***Lot 2 DP 748682
132-138 Killeaton Street, St Ives***

***MP 10_0057 MOD 3 – Modification to reduce
the number of visitor car parking spaces***

Director-General's
Environmental Assessment Report
Section 75W of the
Environmental Planning and Assessment Act 1979

November 2011

DRAWING TITLE:
CARPARK PLANS

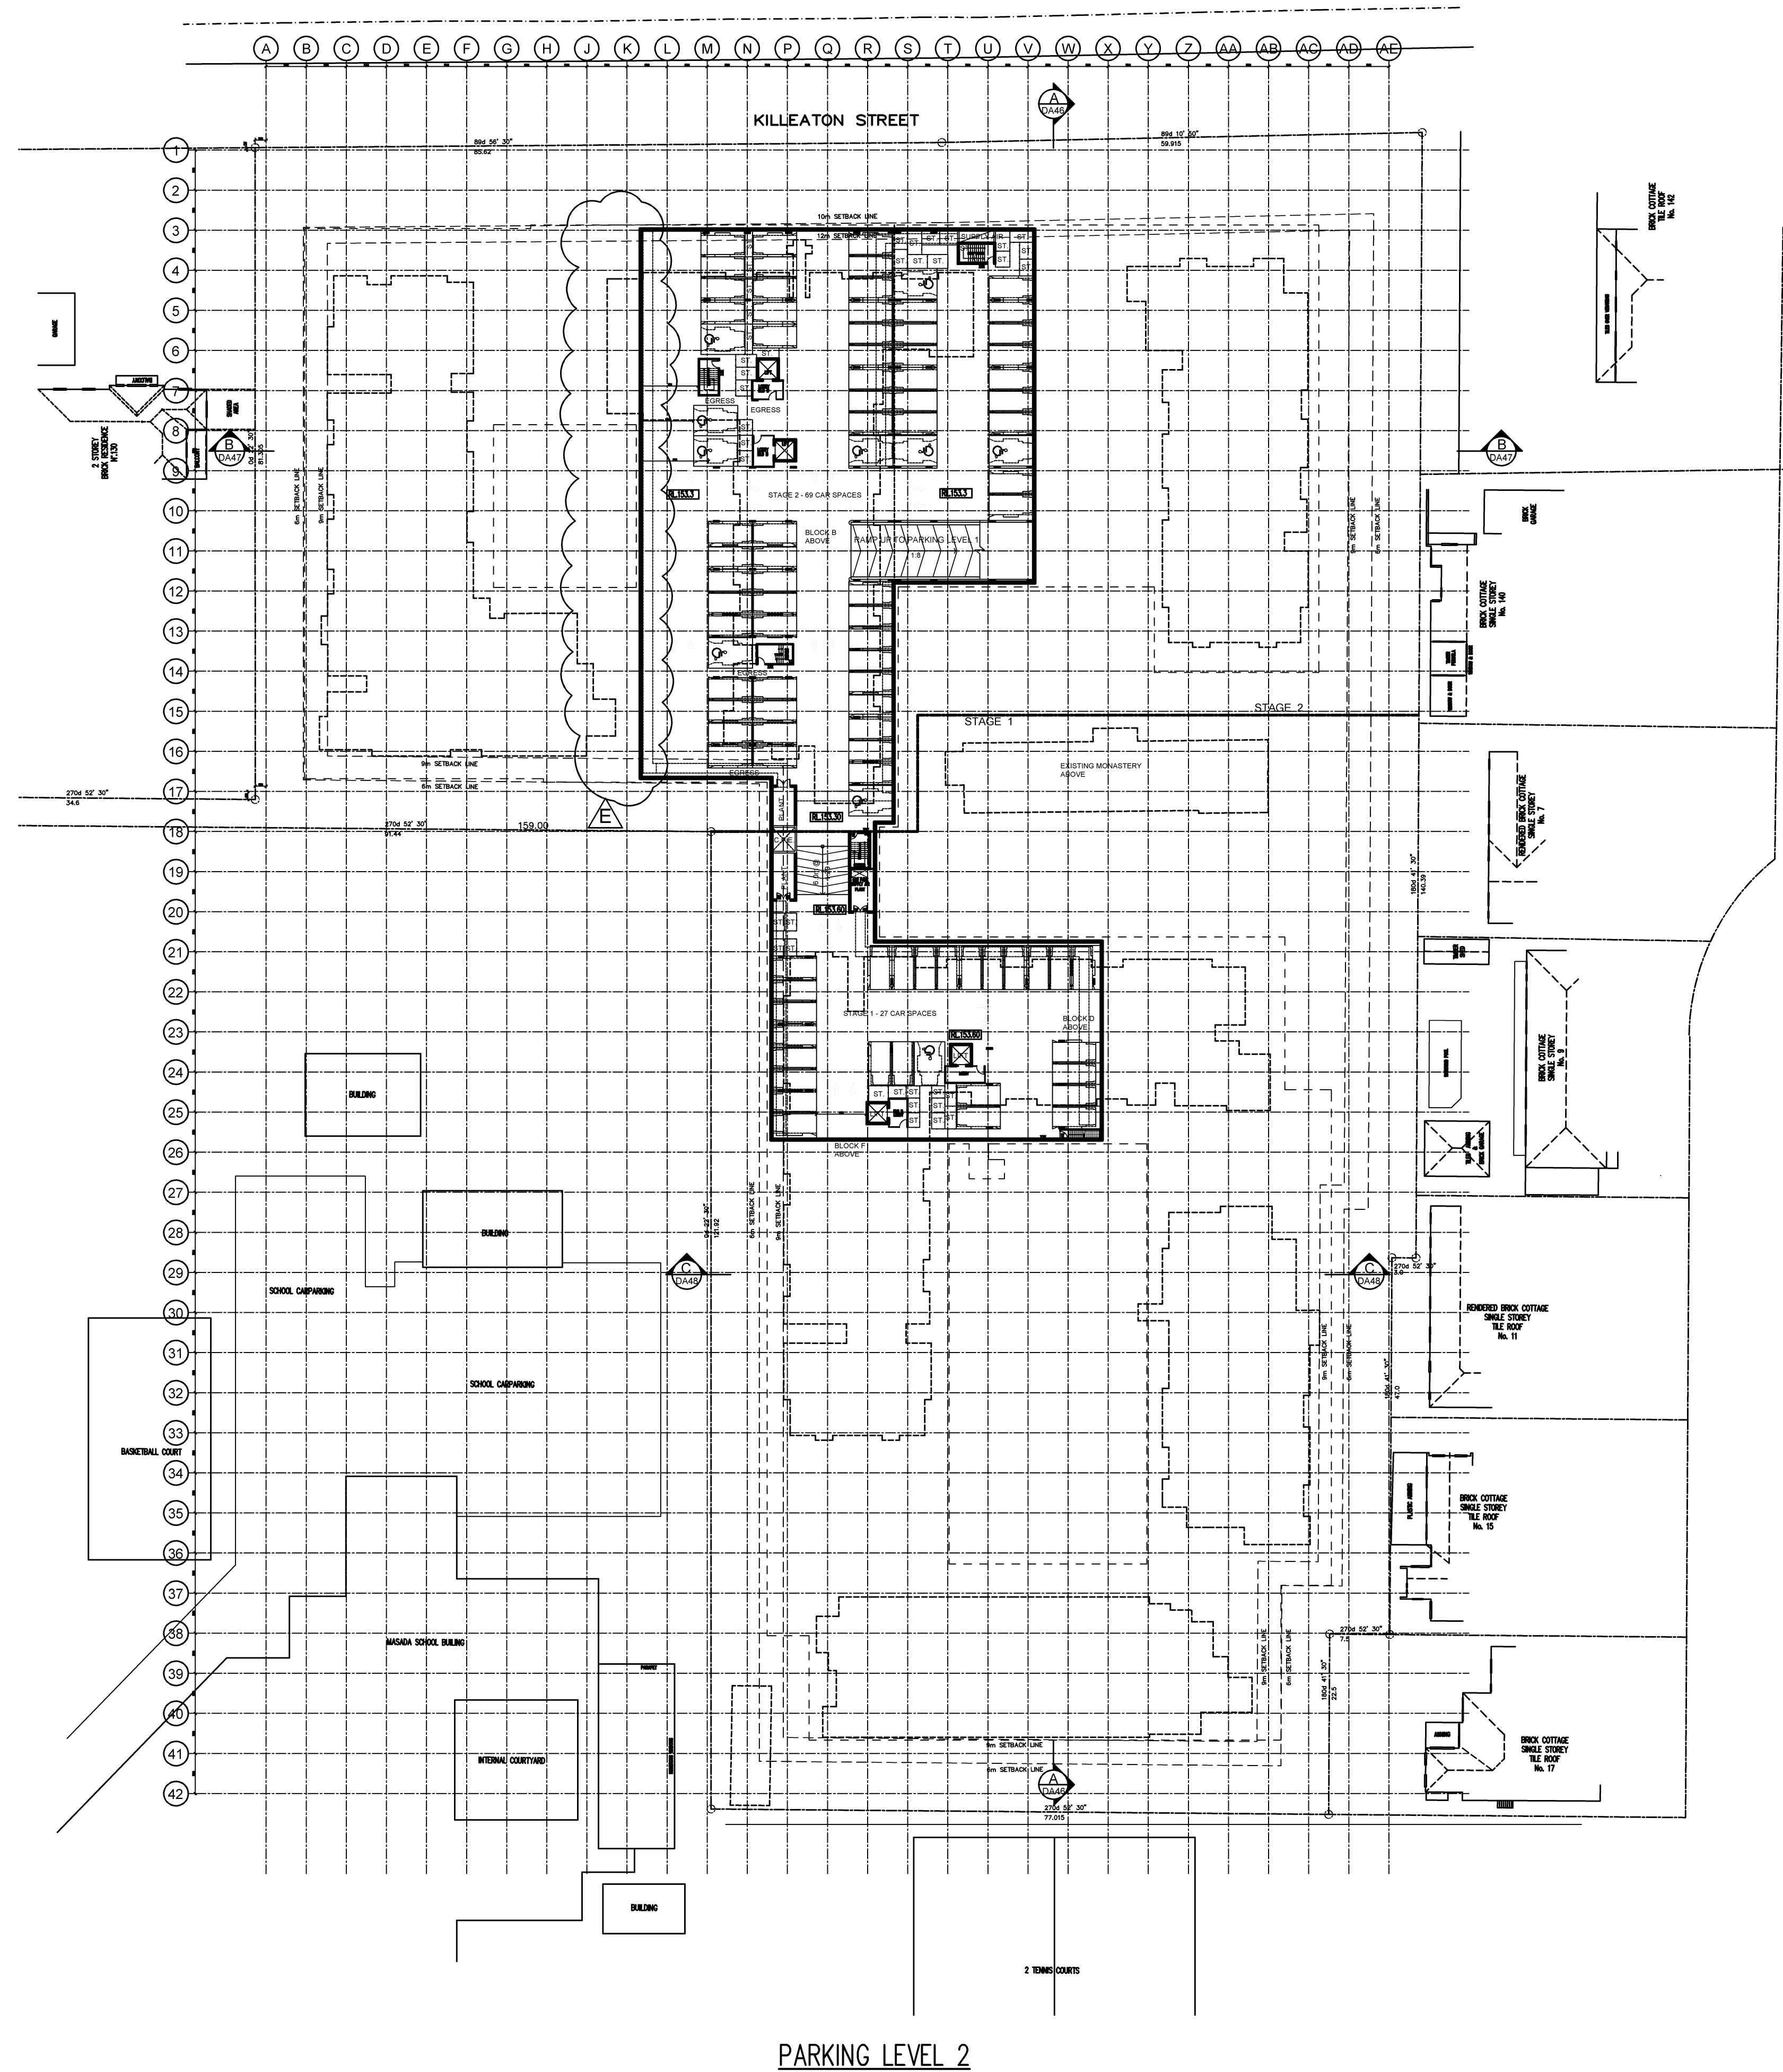
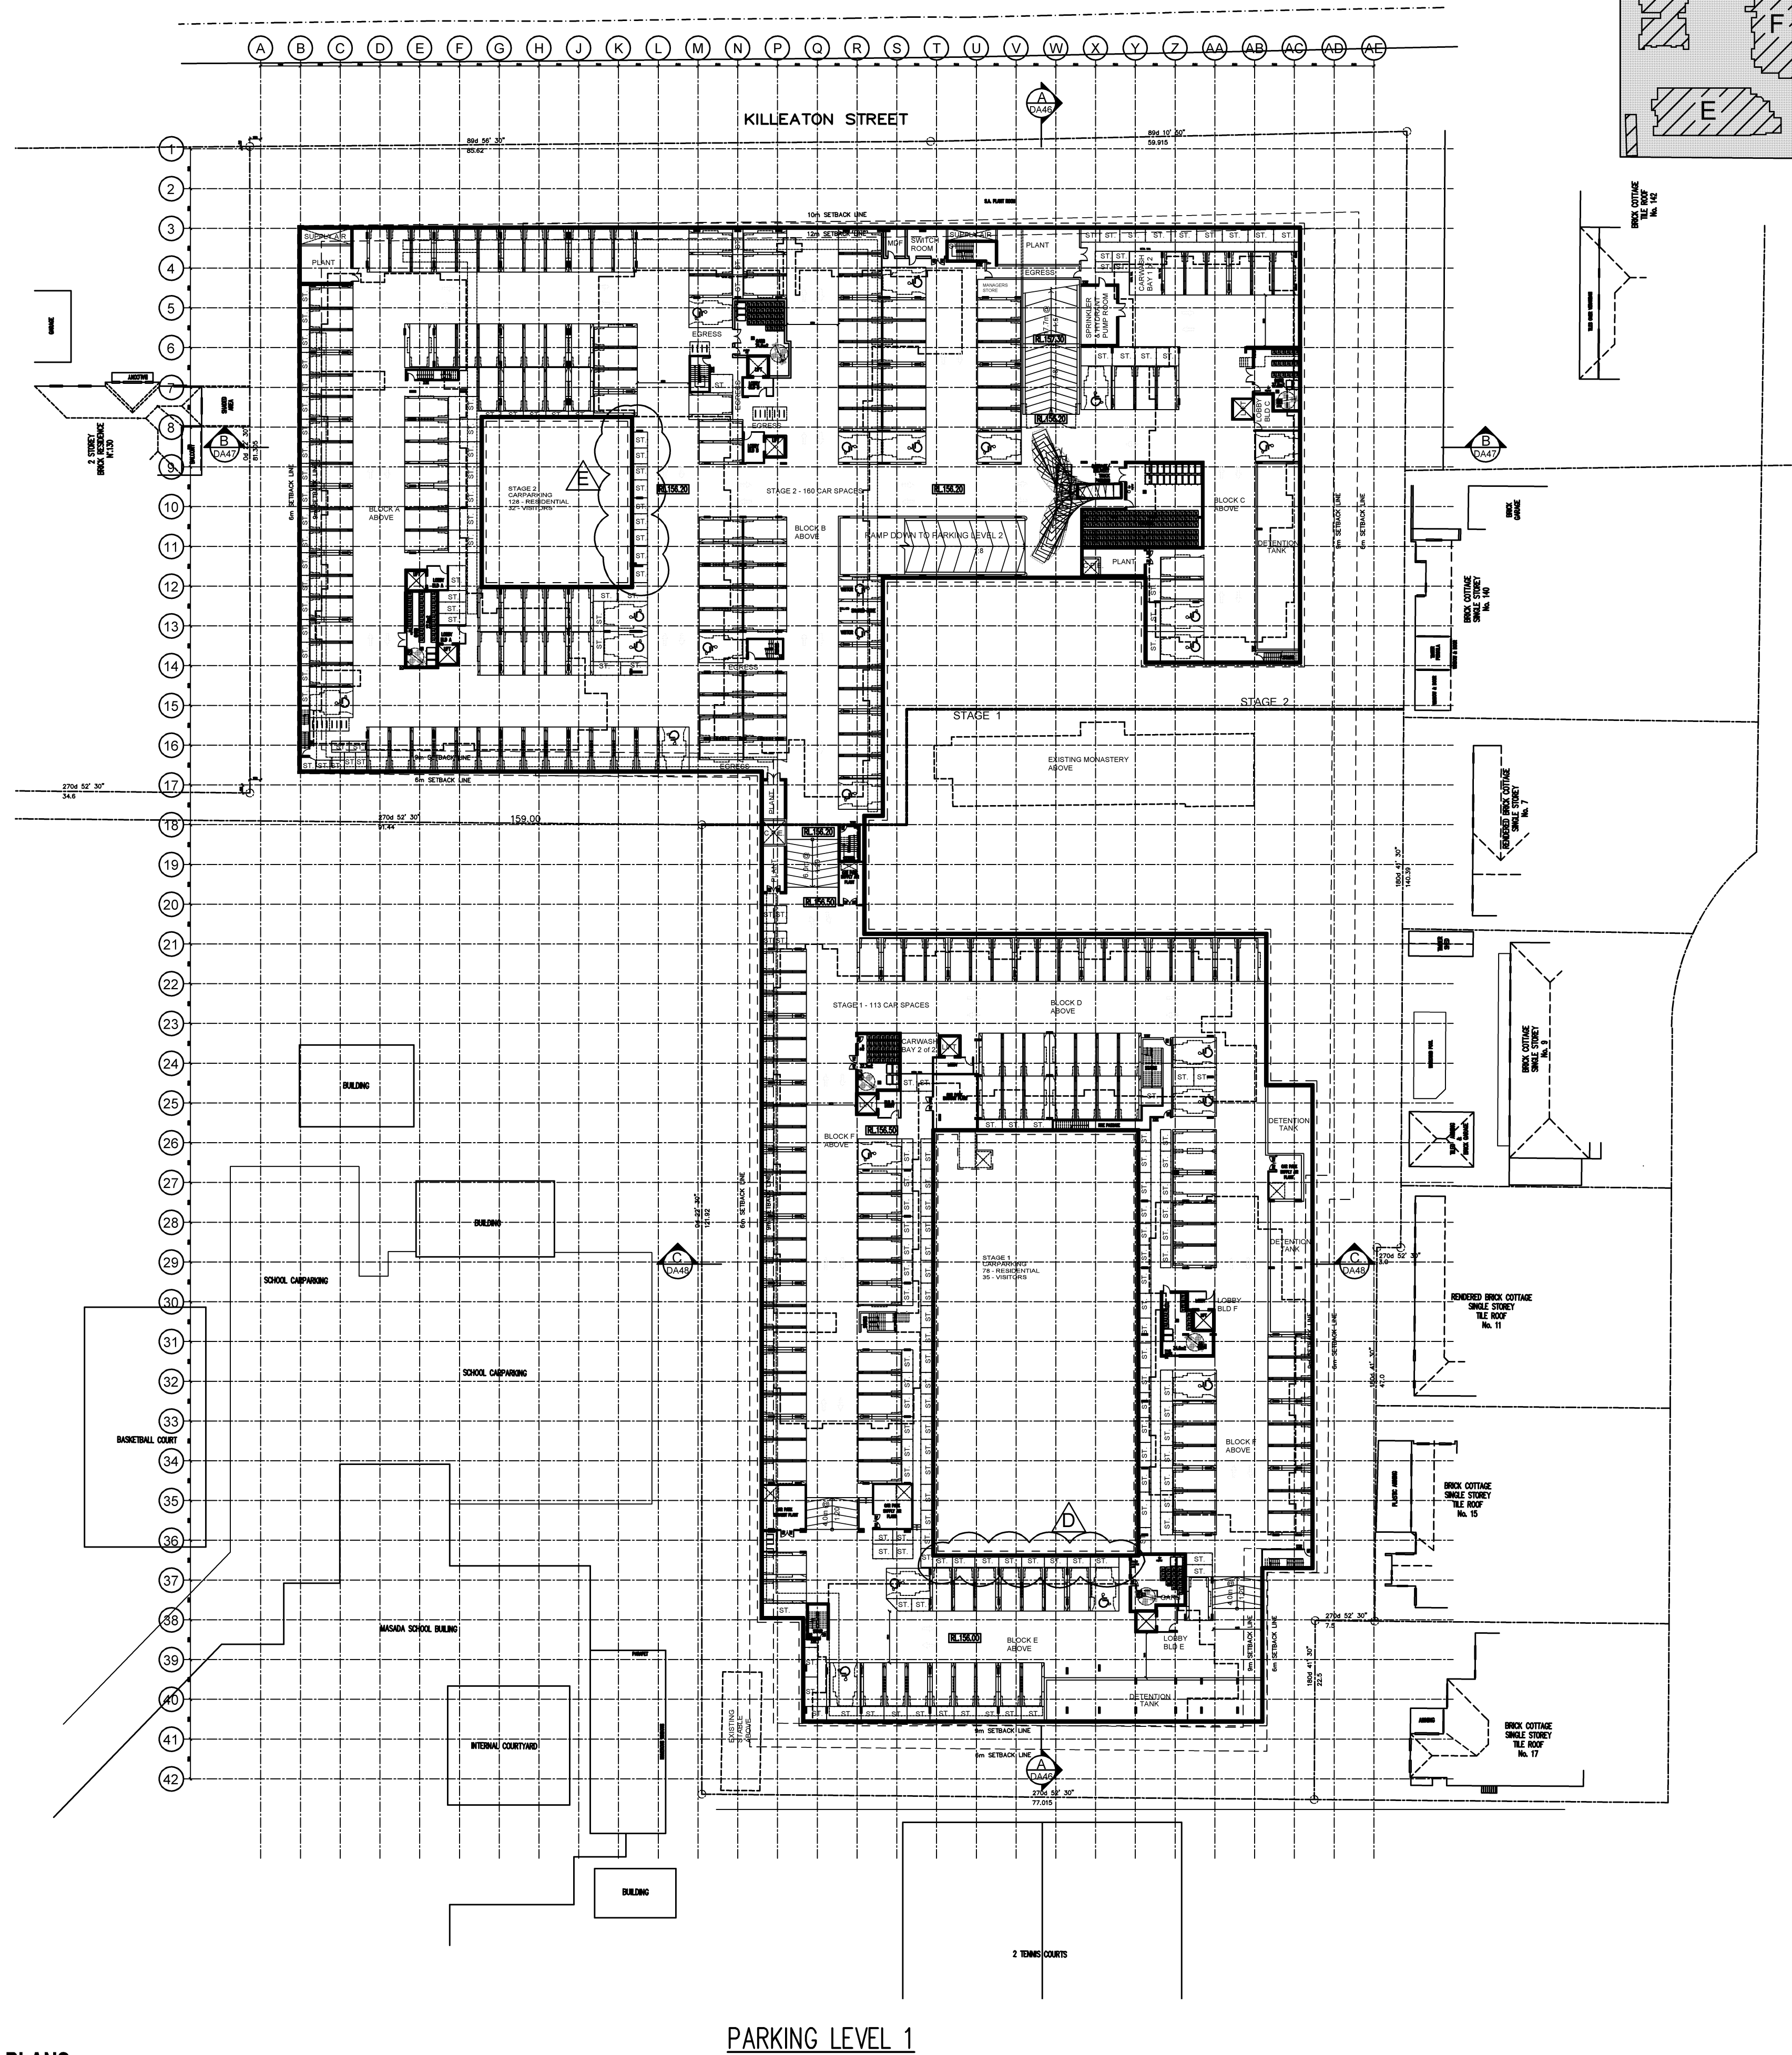
The proposal seeks the following changes to the approved basement layout that provided 396 spaces (321 resident spaces and 75 visitor spaces, excluding the two car wash spaces provided on Level 1) as a result of reducing the proposed number of visitor spaces to 48:

- modify basement level one by reducing the number of car parking spaces provided from 280 to 273 (reduction of seven spaces) by re-arranging spaces in Stage 1 and 2 and modifying the use adjacent the void area below Block A from car parking spaces to storage areas;
- modify basement level two by reducing the number of car parking spaces from 116 spaces to 96 (reduction of 20 spaces) by deleting the car parking spaces provided in Stage 2 along the western basement wall and re-arranging spaces in Stage 1; and
- relocation of storage space.

The modified basement layout is considered to have appropriate regard to the conditions of Approval, including the provision of spaces designated for persons with a disability.

Council has not raised concerns with the proposed amended basement design.
